Reference No:	2024/44/93431/W
Site Address:	Land at, Penistone Road, Fenay Bridge, Huddersfield, HD8 0AW
Description:	Discharge of details reserved by conditions 22 (BEMP), 25 (boundary treatment), 30 (retaining wall materials), 32 (external lighting), 34 (waste collection) and 35 (cycle storage) of previous permission 2022/93154 for erection of 68 dwellings with associated access, parking, open space, landscaping and infrastructure works (including installation of surface water attenuation tank)
Recommending Officer:	Katie Chew

DECISION – Discharge of Condition – Refuse

Officer Report:

Application: 2024/93431

Title: Sheet Pile Retaining Wall			
Contract: Fenay Bridge			
Client: Alfa Site Services			
DRG. STATUS: PRELIMINARY ISSUE			
Paper Size: A2	Scale: NTS	Designed By: OC	Checked By: AL
Internal Reference Number: 24219			Date: 07/11/24
Drawing Number: 24219-PS-XX-XX-DR-Y-0001			Issue: D

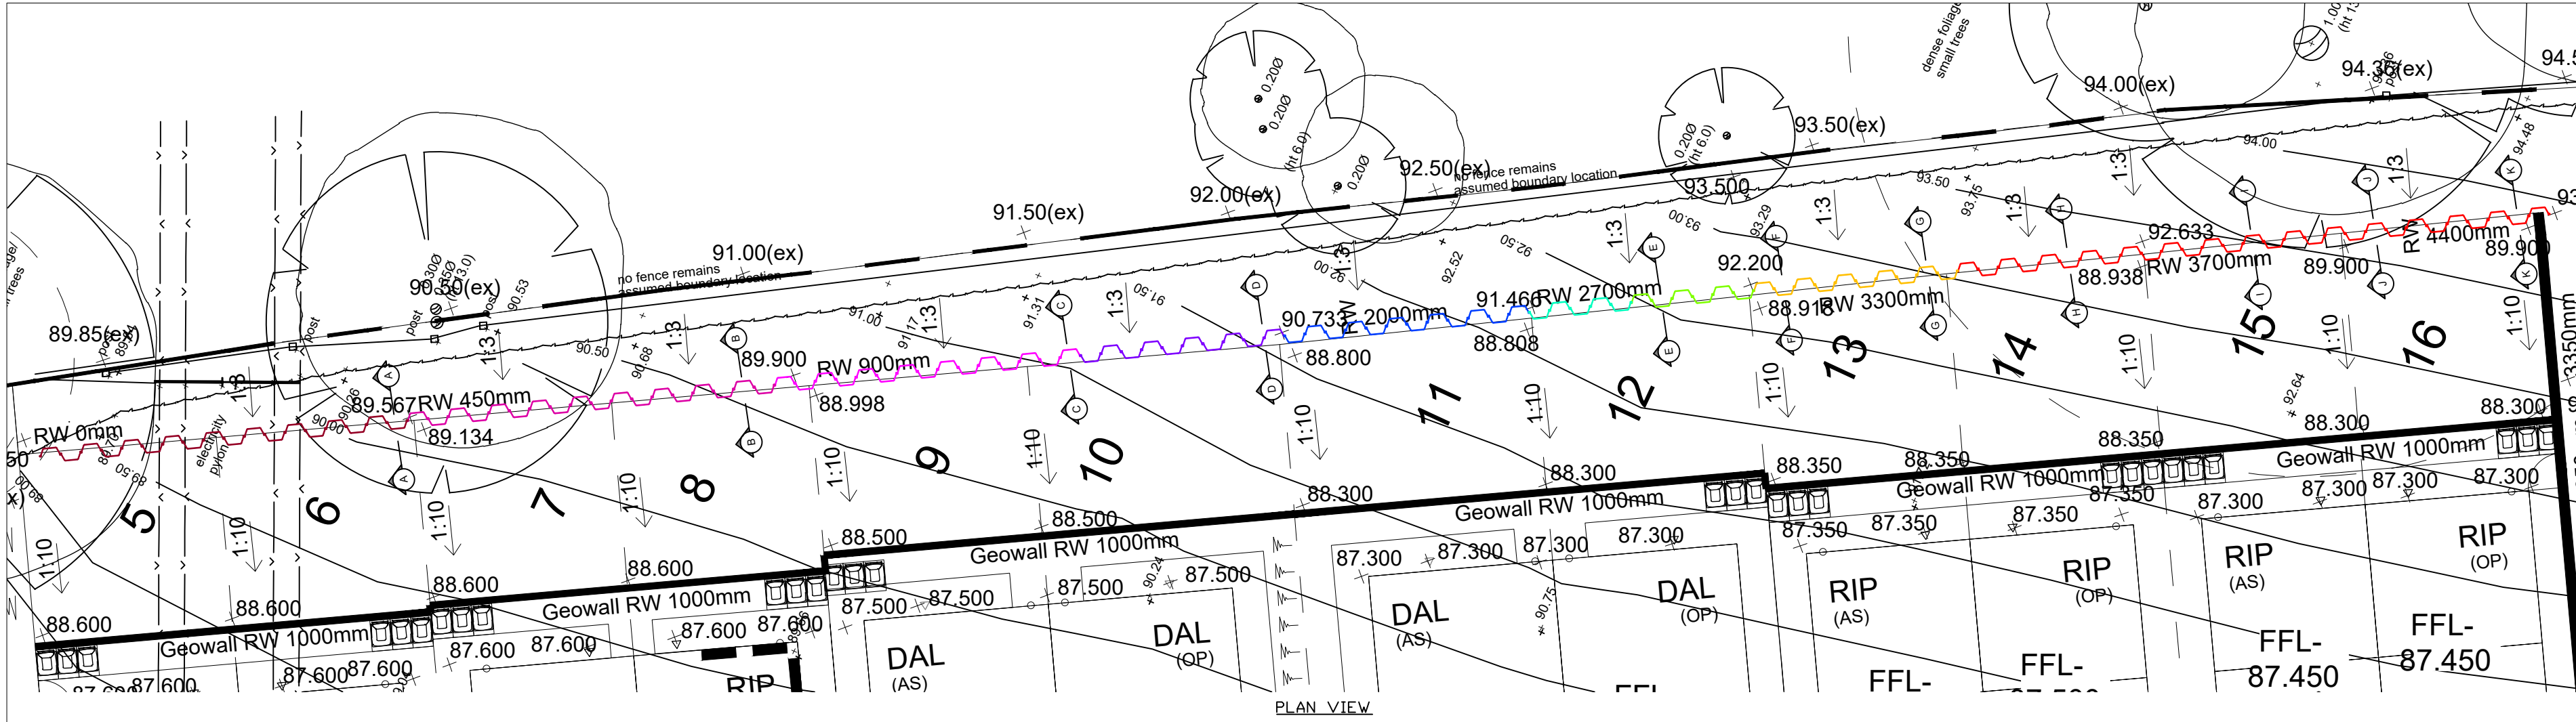
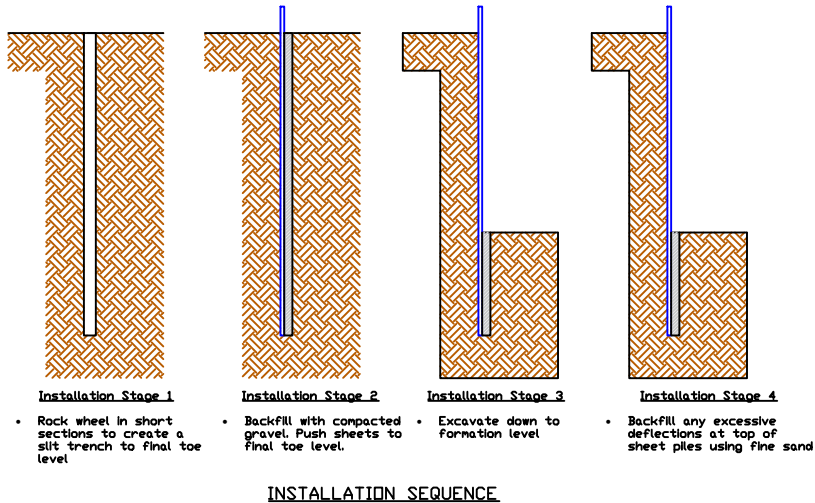
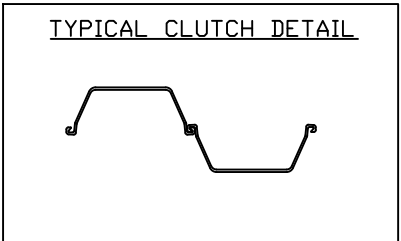
To the rear of plots 5 to 16 Sheet piling and 1800mm timber fence is proposed. The sheet piling has Vertical feather edge Timber panels fixed to it. This, in effect, results in a fence upon a fence, and like the Geowall considered above has the potential to be overly dominant and monotonous if the same colour. Conversely, subject to suitable colour variation between the true fence and sheet piling 'cladding', it could be supported. No such detail of colours have been received to assess however and, given the various concerns raised, have not been sought at this time.

DRAWING TITLE:
2.0m Acoustic Timber Fence

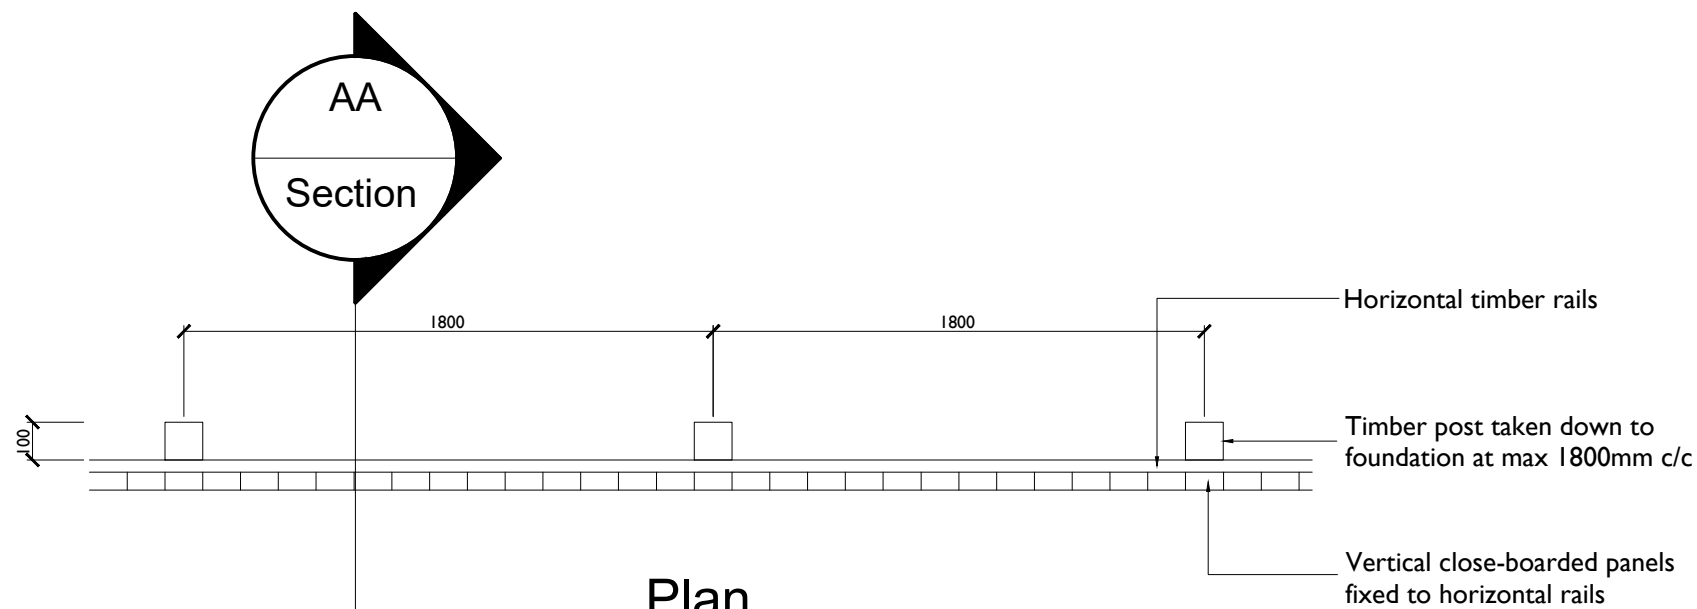
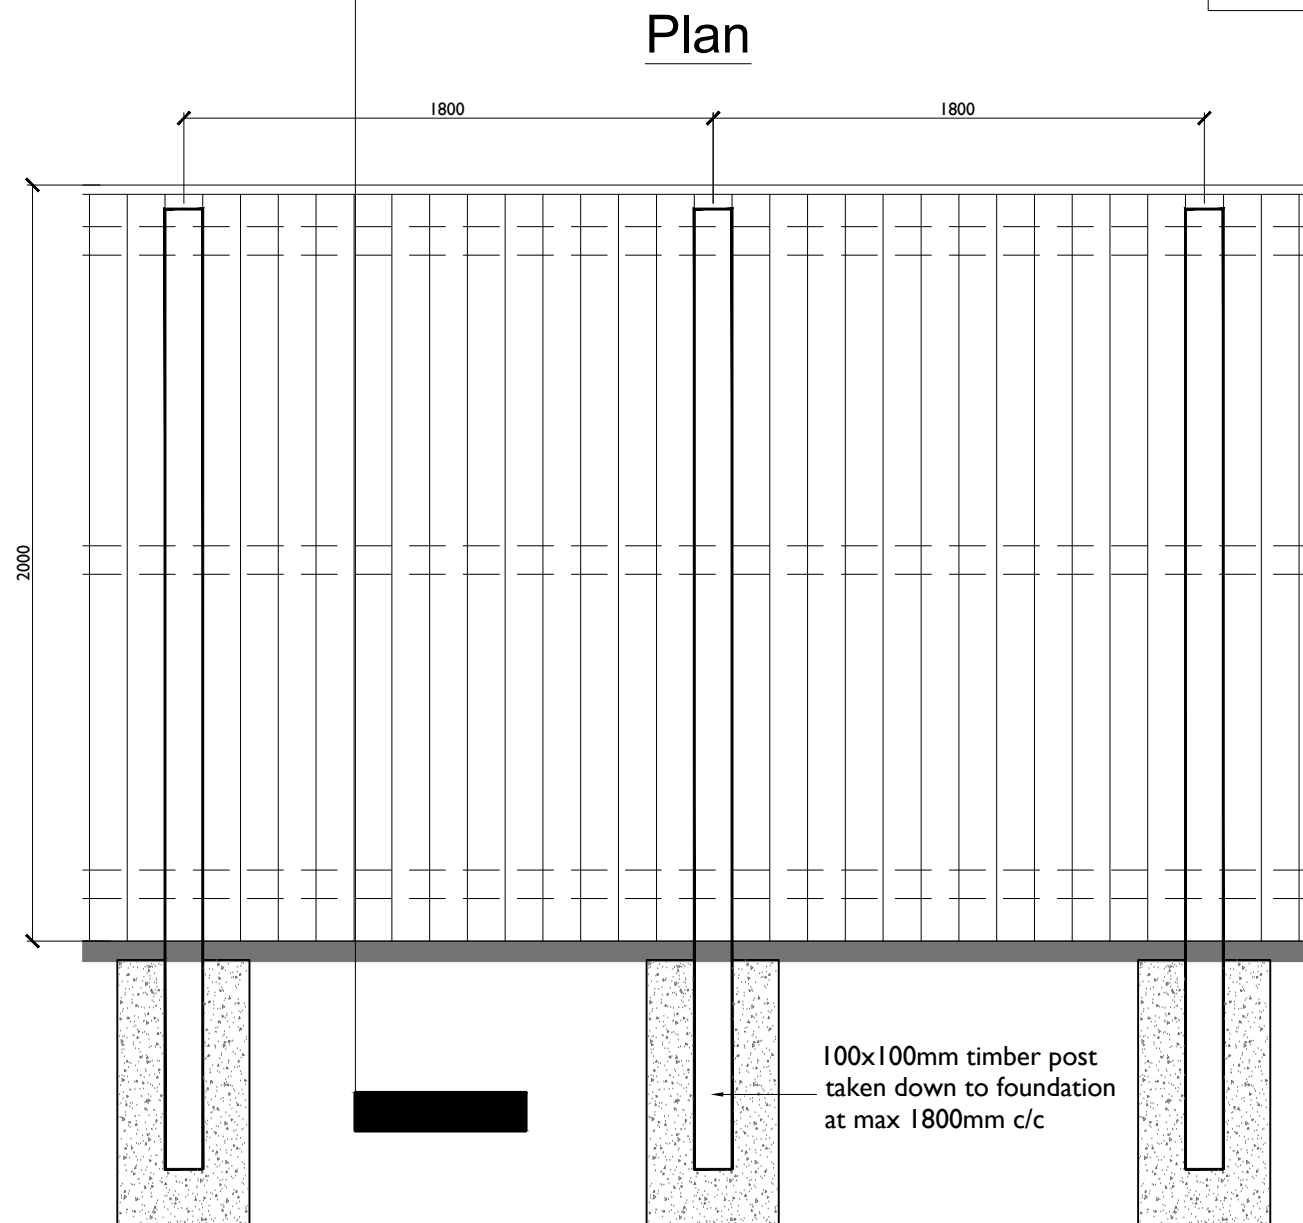
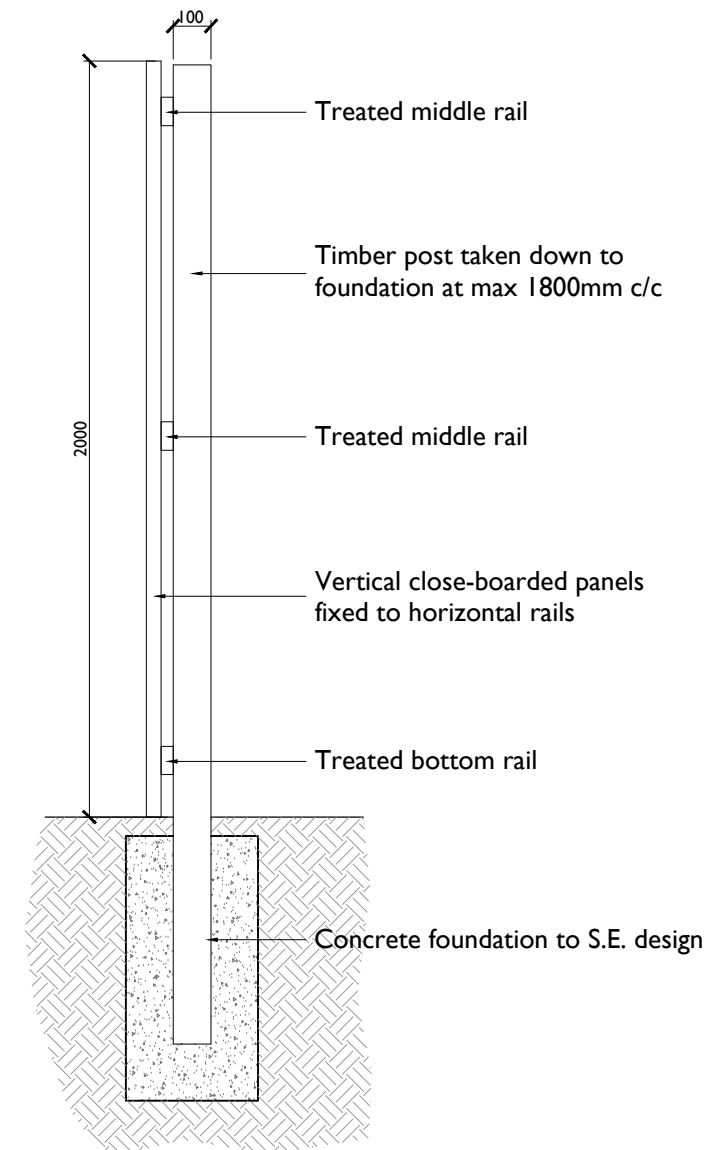
Boundary treatments such as the proposed 450mm timber knee rail and 2m acoustic timber fence are considered to be located in suitable areas within the site, be of an appropriate size and of a sympathetic material. The 1.8m feather edge fencing is also deemed as being an appropriate boundary treatment to dwellings located within the estate.
